Your Ref: ACP-324568-26

Our Ref: SID-DG-2026-041

Proposed Strategic Infrastructure Development (SID): Barnesmore Gap Greenway Project, County Donegal.
--

Outlined below are heritage-related observations/recommendations of the Department under the stated headings.

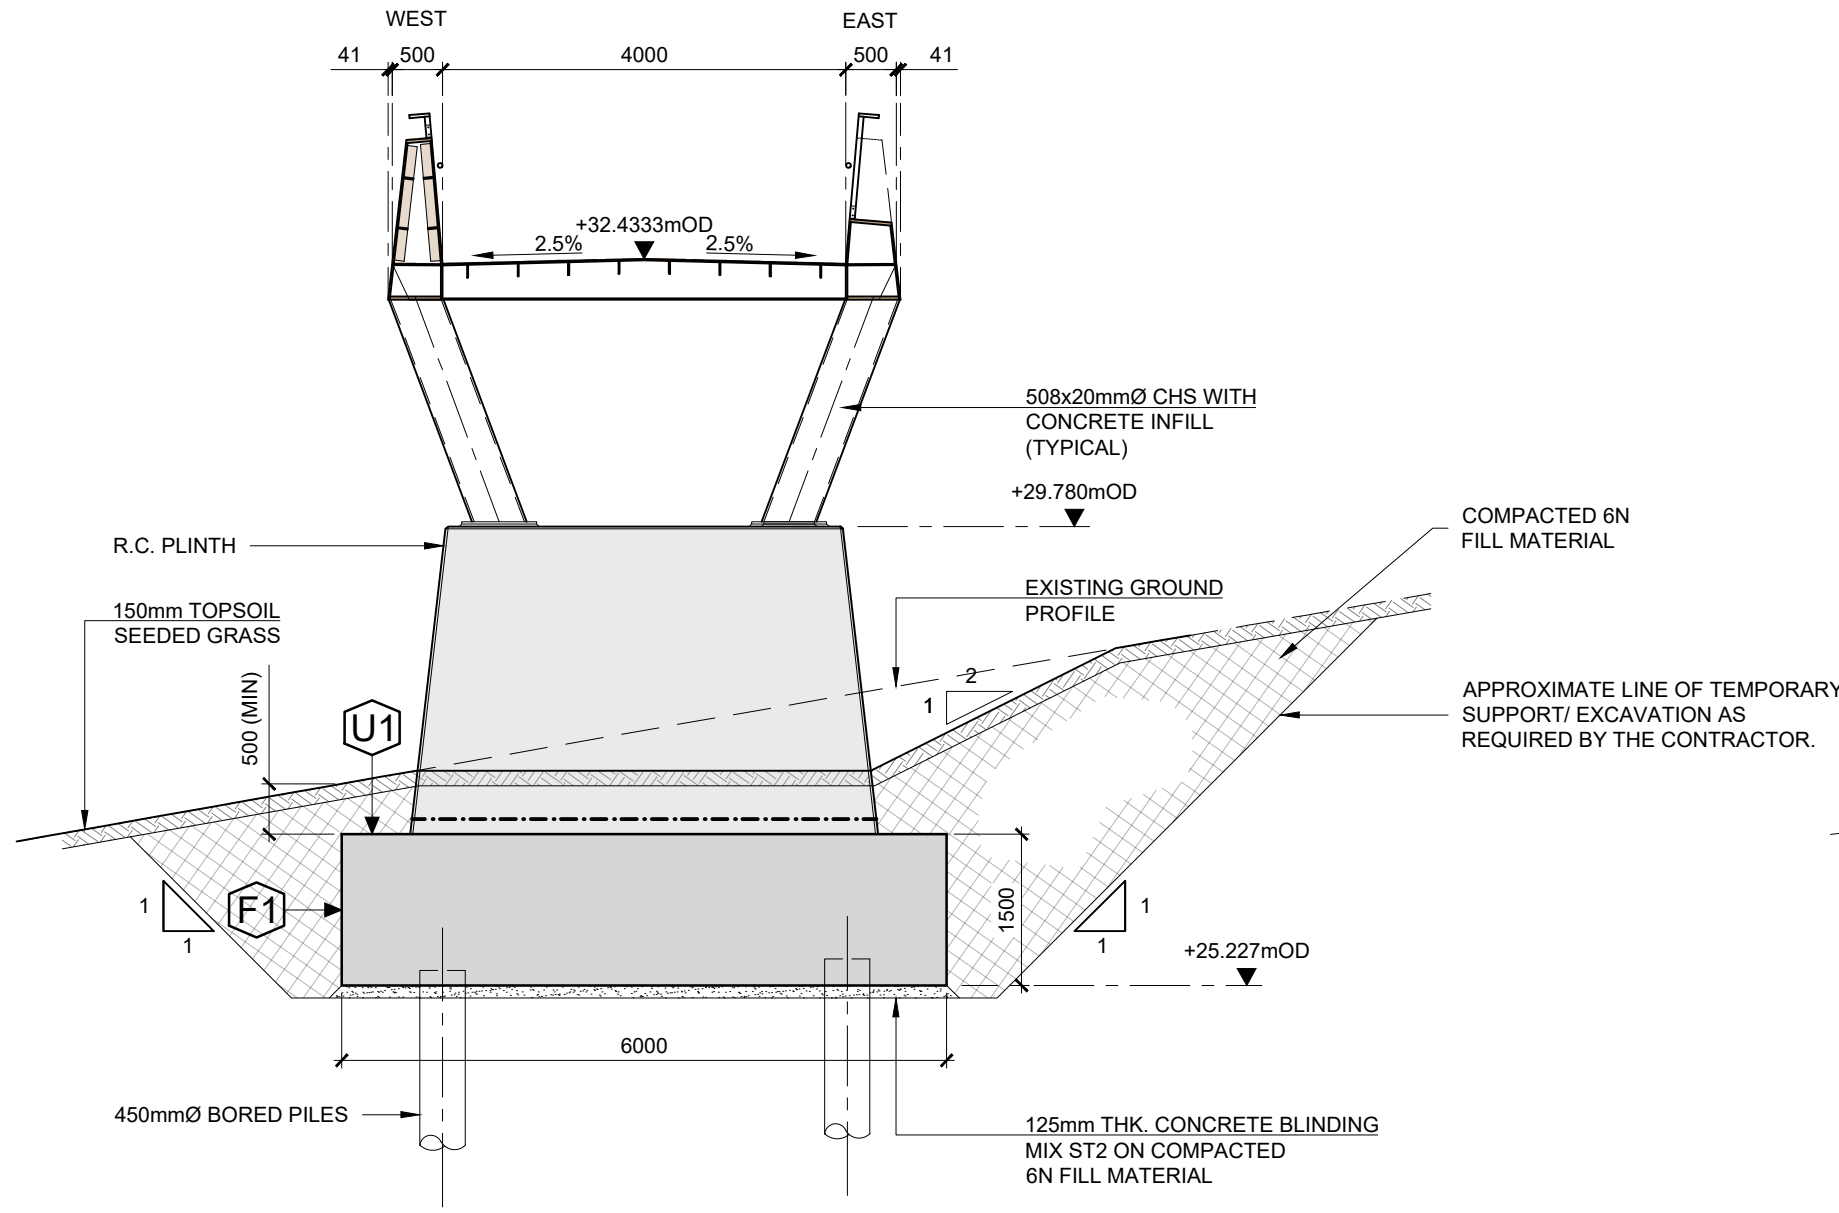
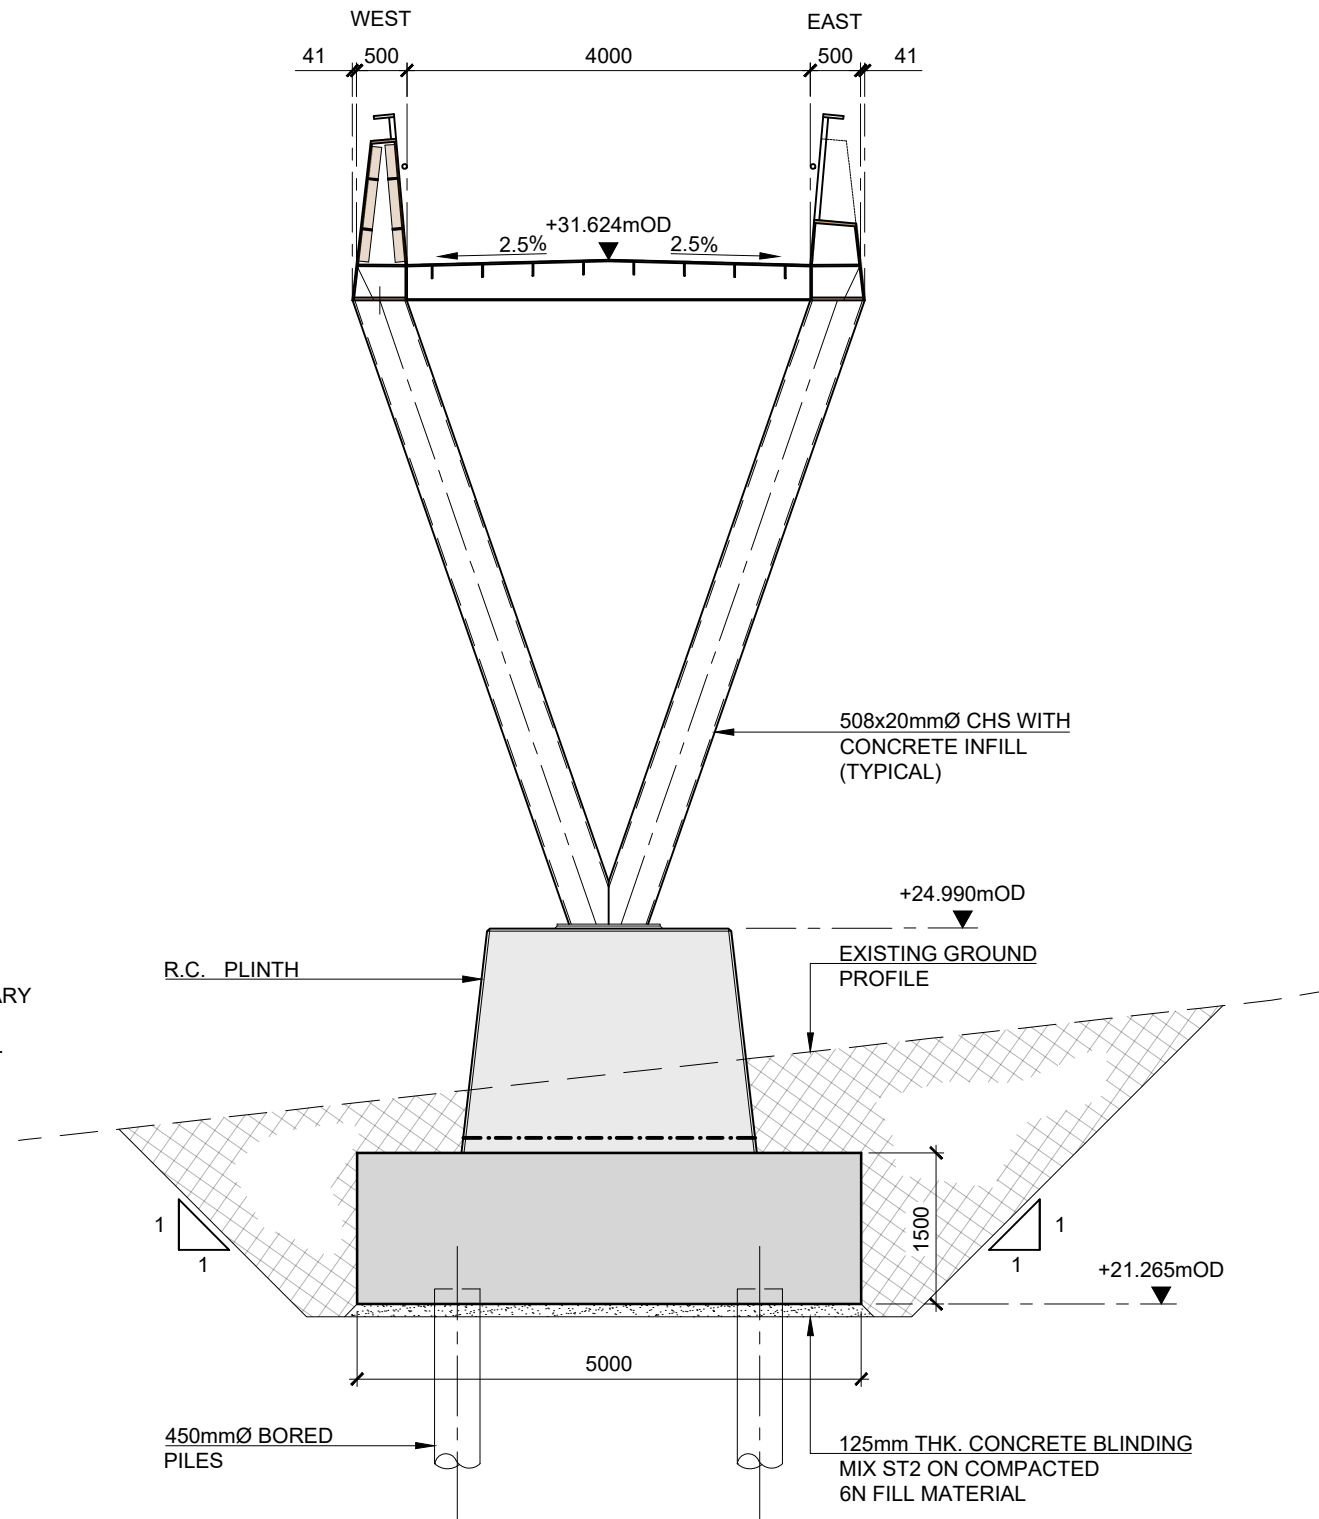
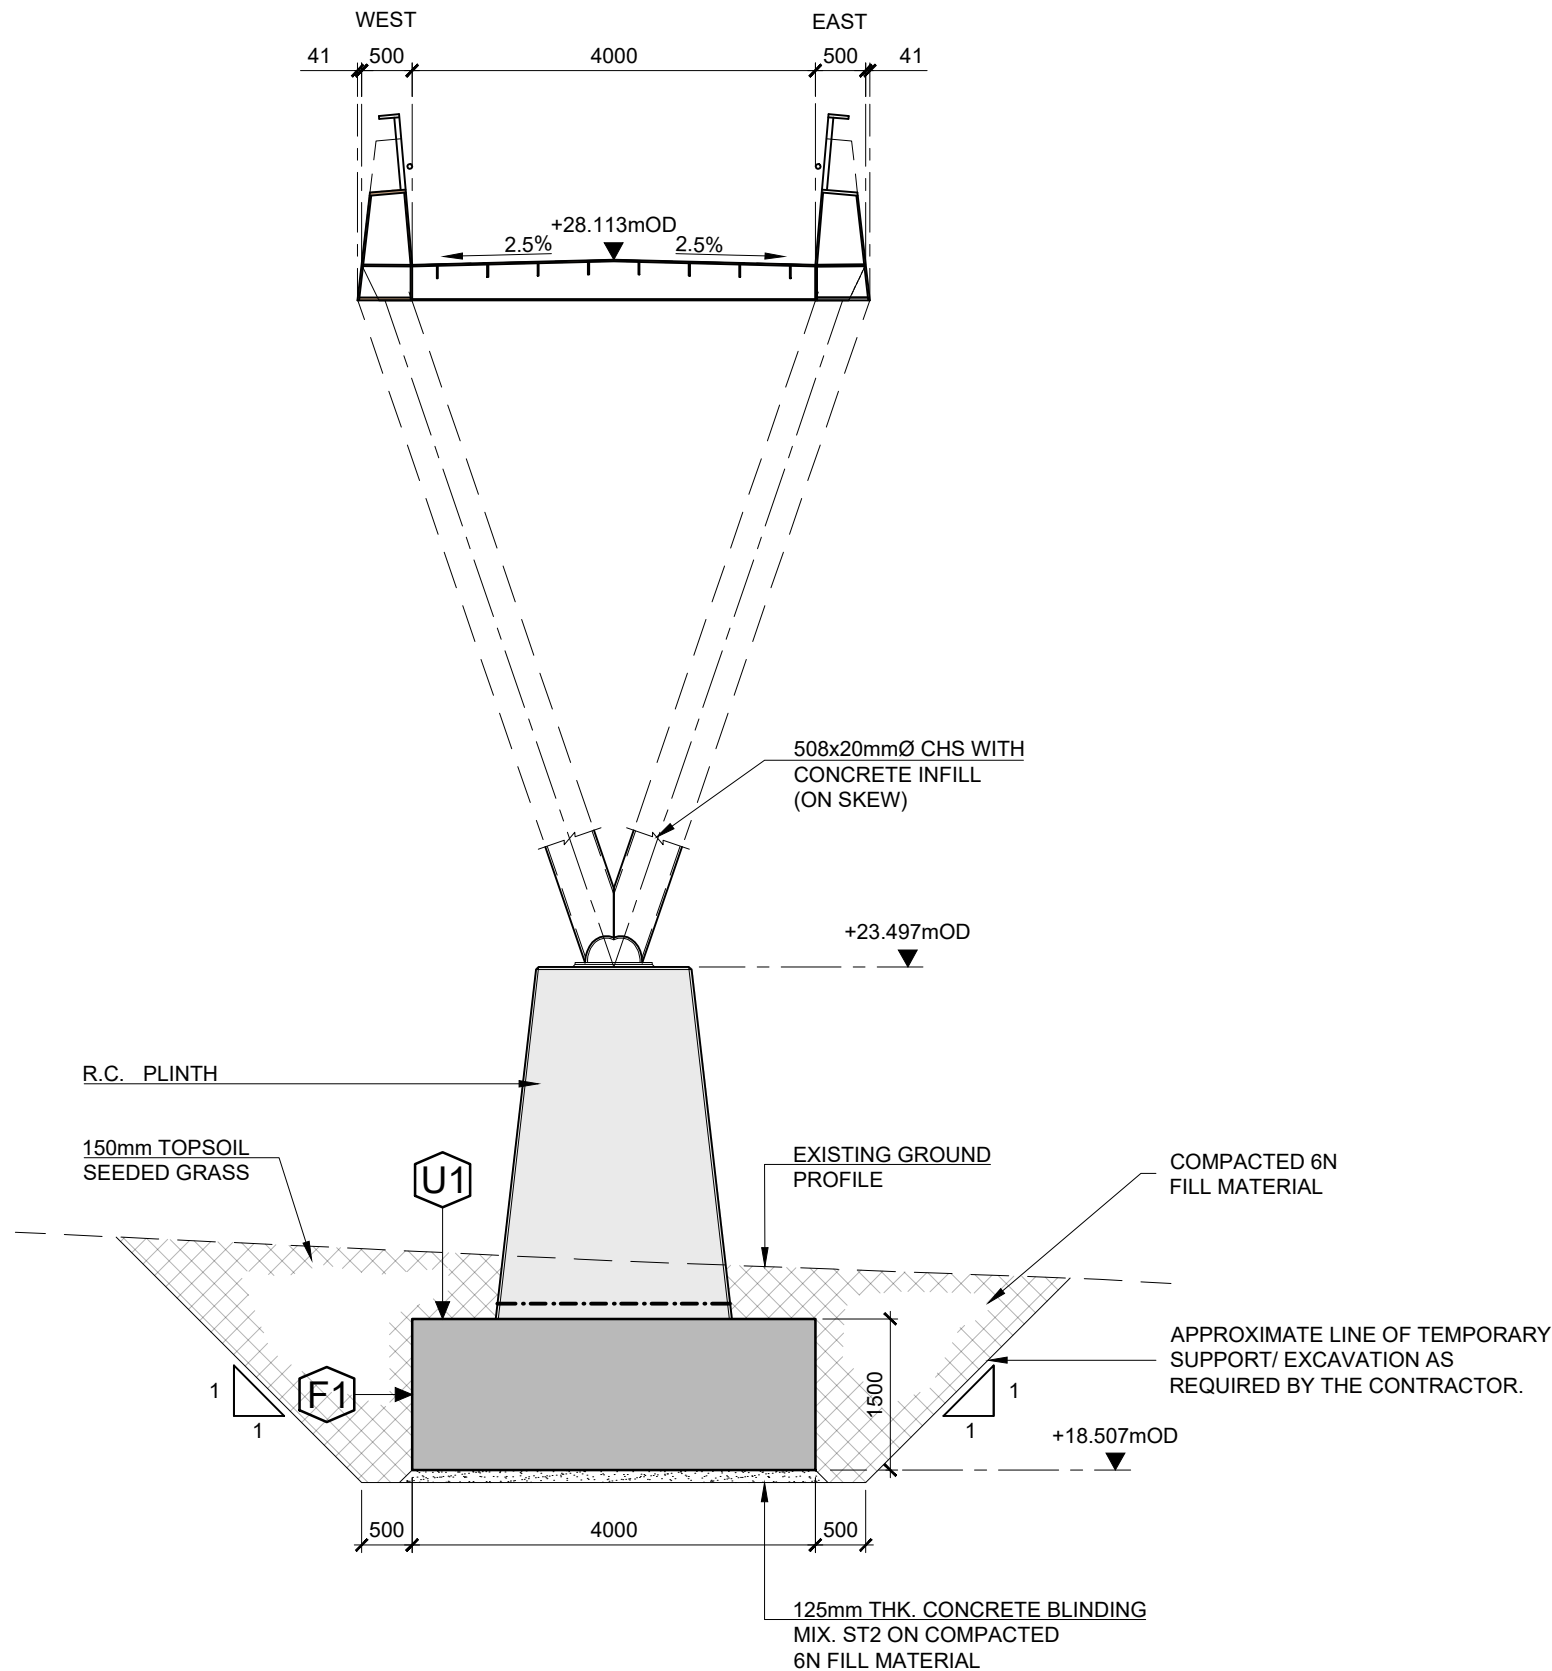
A detailed site-specific construction method statement for the proposed River Eske crossing is required, including bridge foundations, working areas, temporary access, lifting/scaffolding, concrete operations, runoff management, pollution-response procedures, environmental supervision and construction-phase water-quality monitoring. Furthermore, the commitment to no instream works, no riverbank excavation and no direct outfalls to the River Eske should be explicitly secured.
